final grading V_2.pdf Markup Summary

Subject: Callout
Page Index: 4
Date: 4/19/2021 1:30:29 PM
Author: dsdrice
Color: ■
Layer:
Space:
Page Label: [4] 4 2514901GF01 - GF01

Subject: Callout
Page Index: 5
Date: 4/19/2021 1:31:09 PM
Author: dsdrice
Color: ■
Layer:
Space:
Page Label: [5] 5 2514901GF01 - GF02

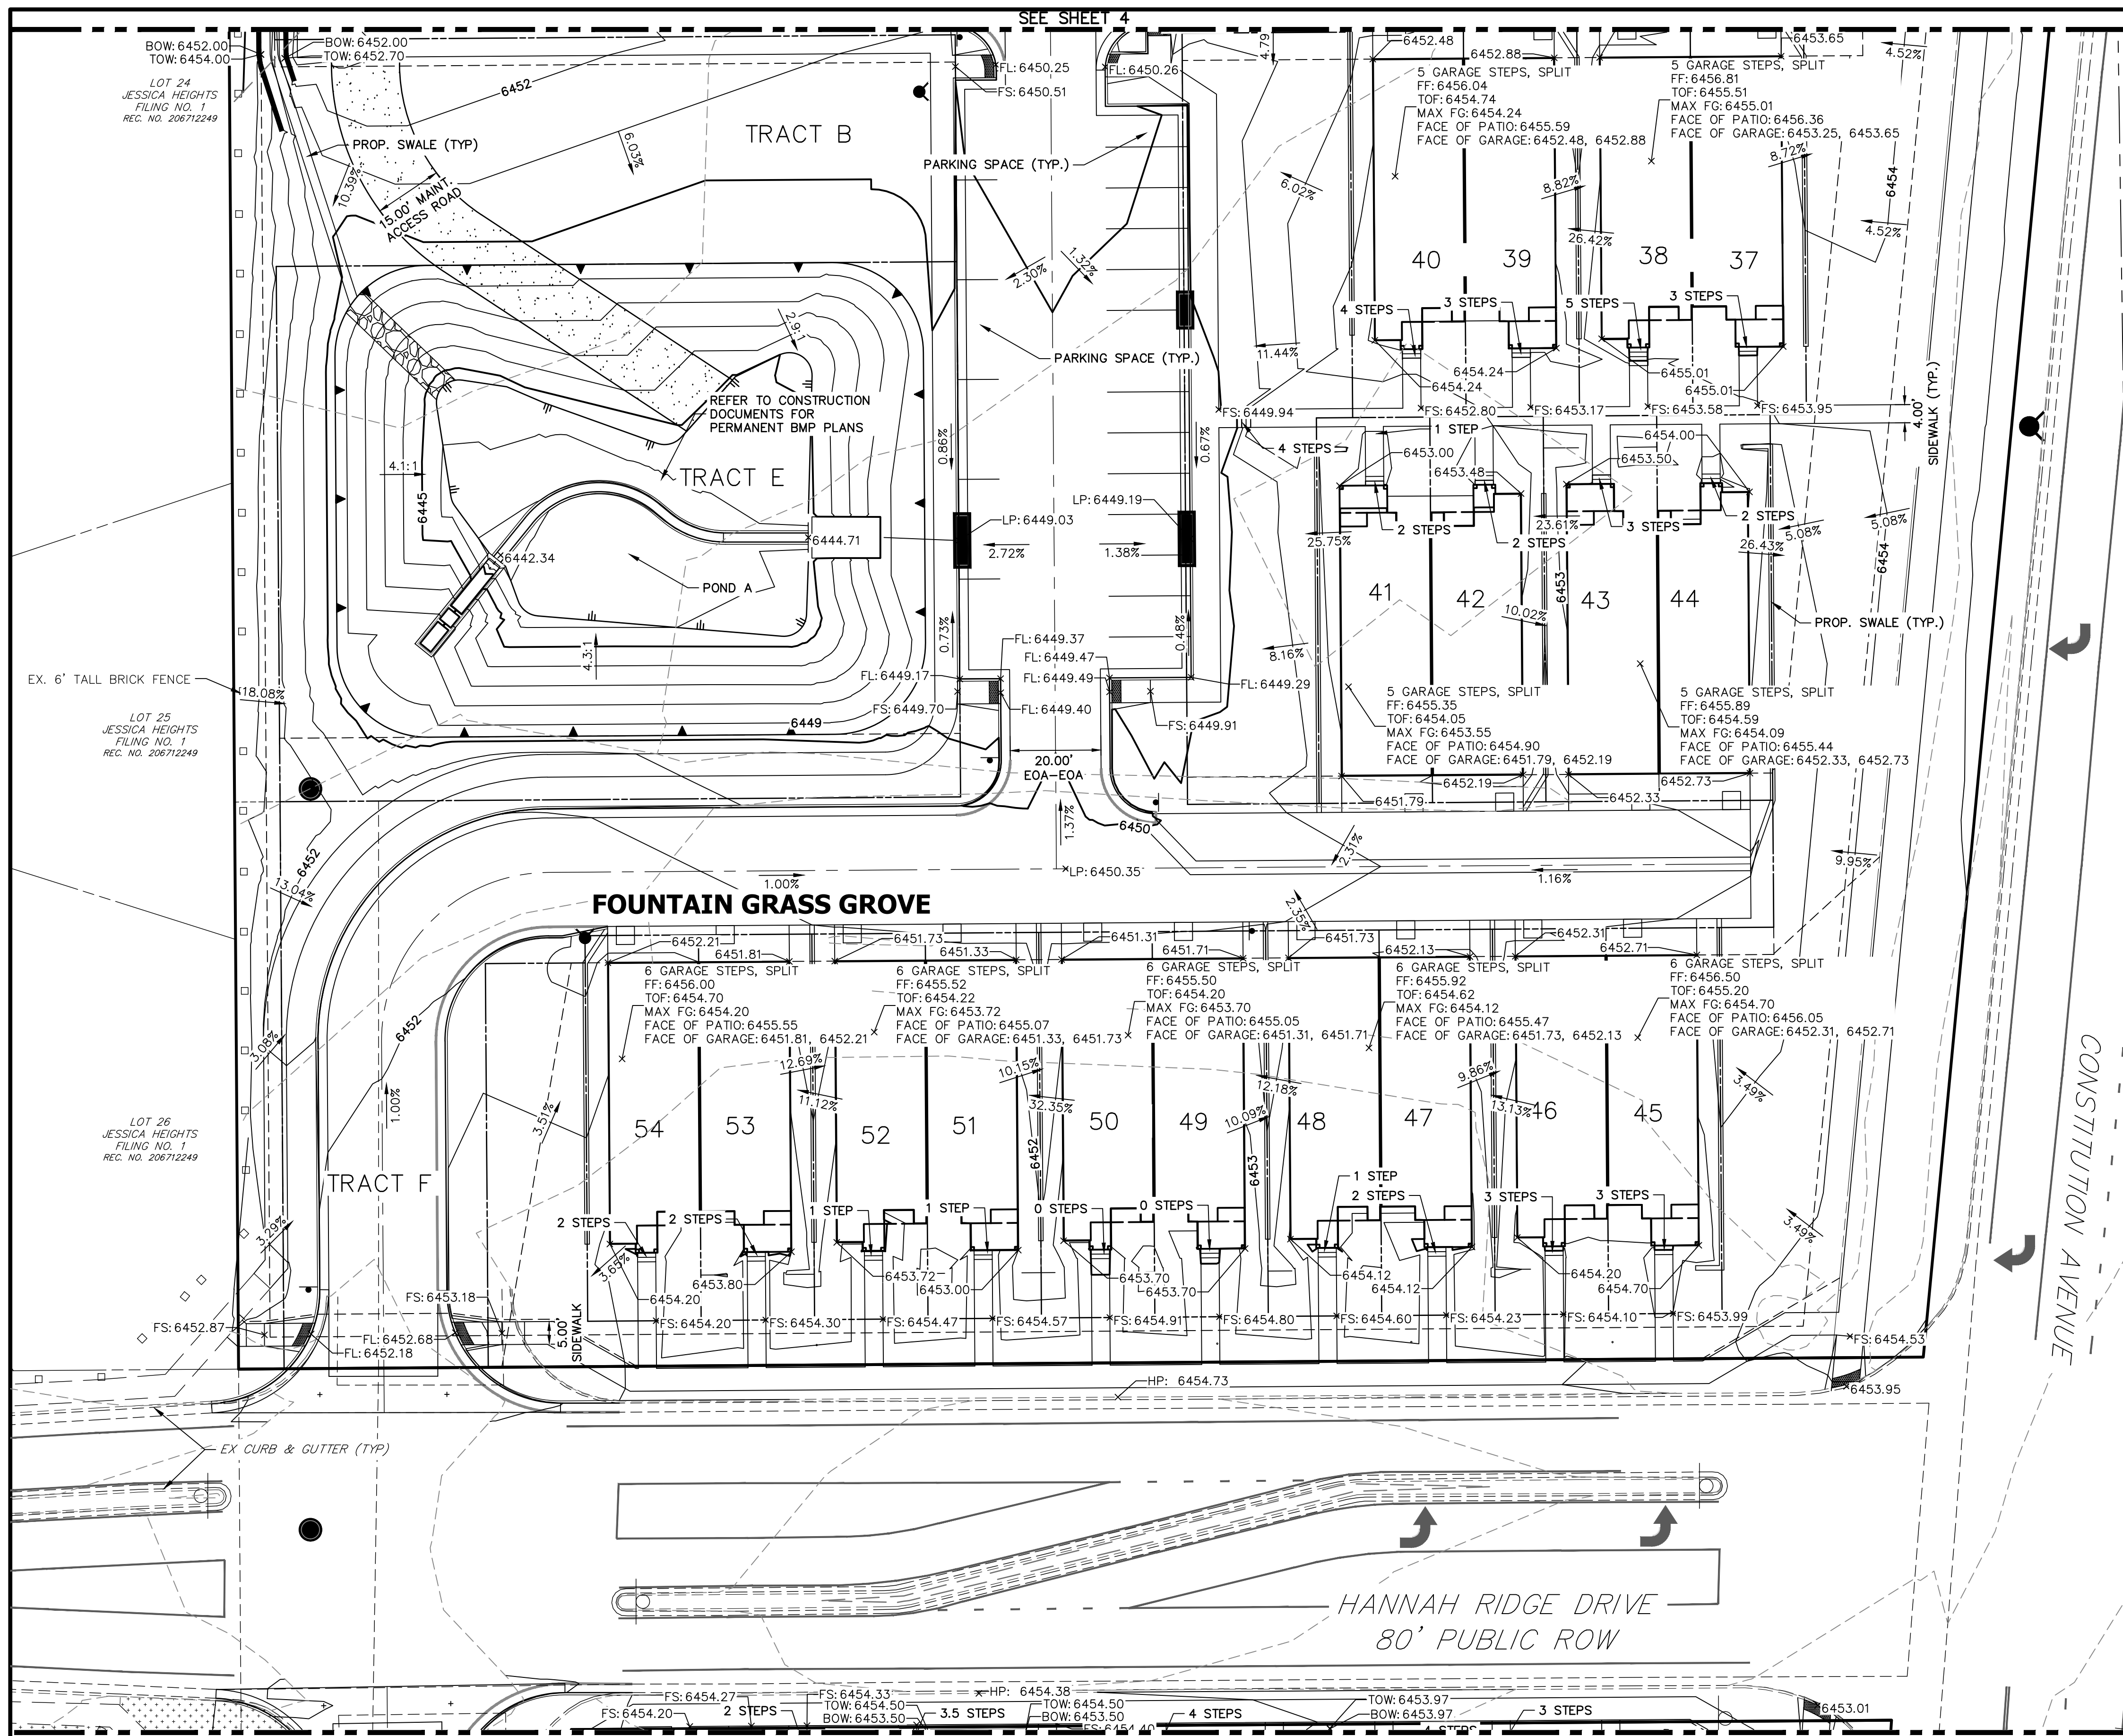
Contours changed - don't match gutter pans?

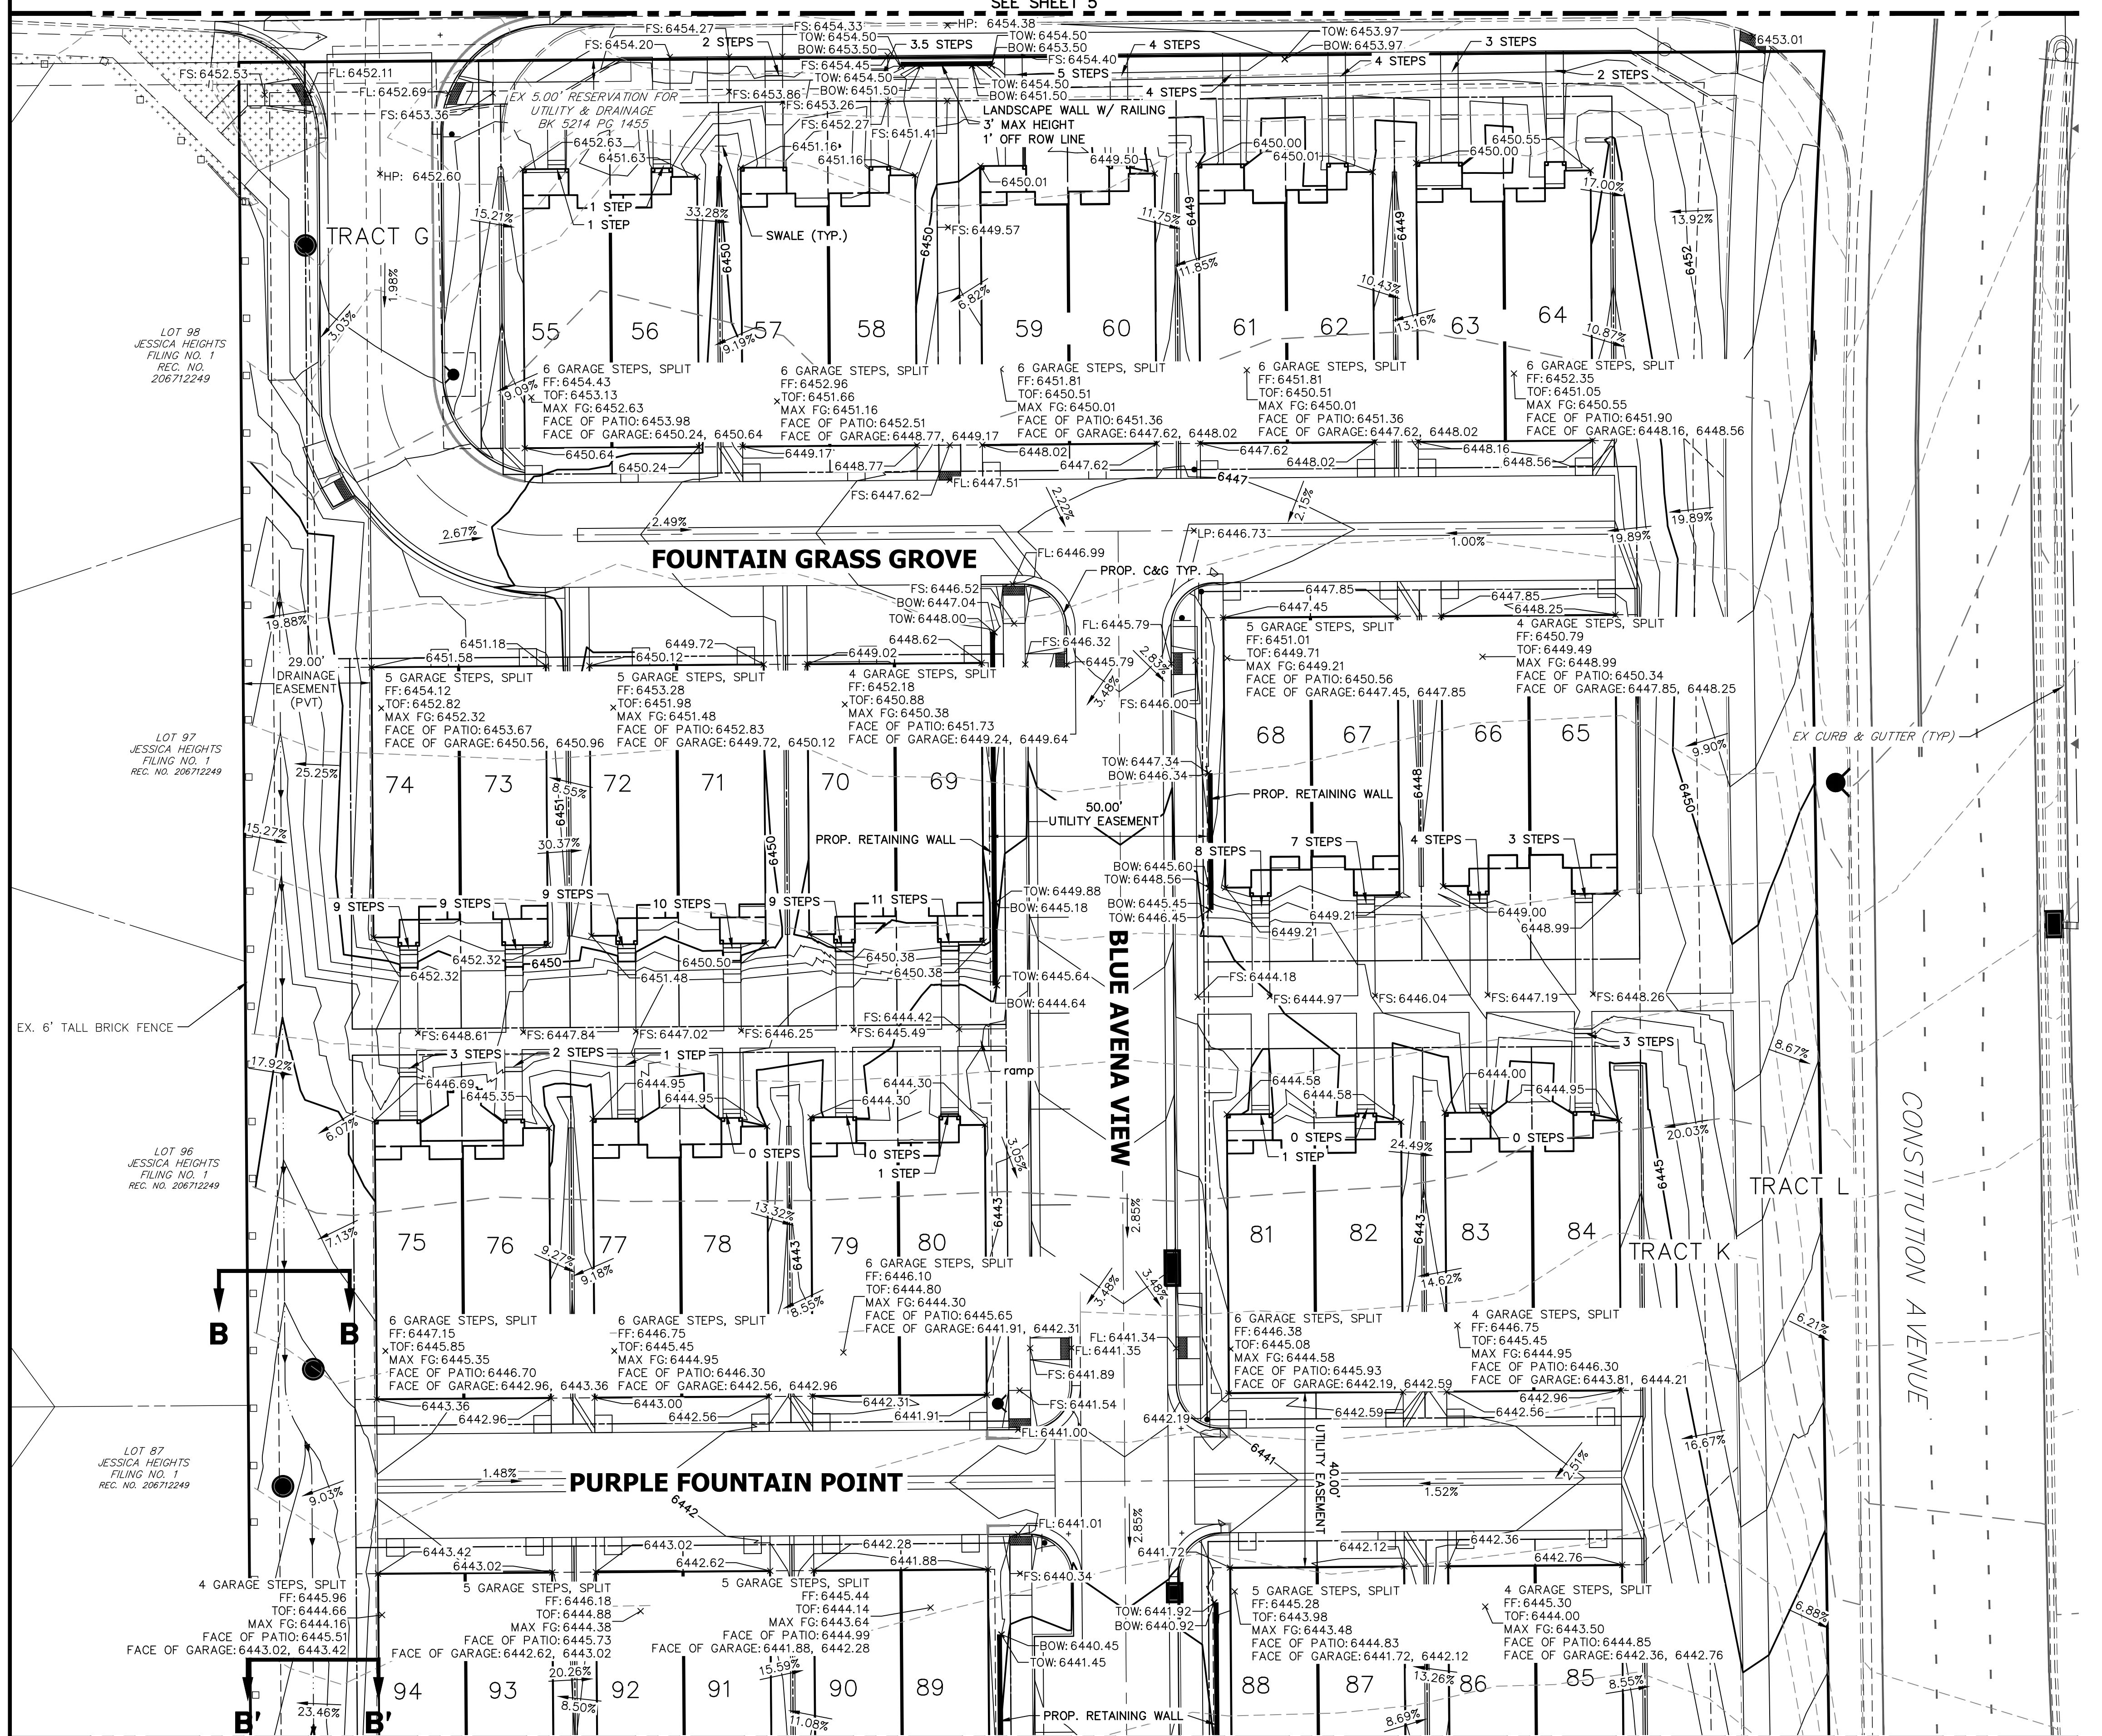
Delete contours across Hannah Ridge Dr.
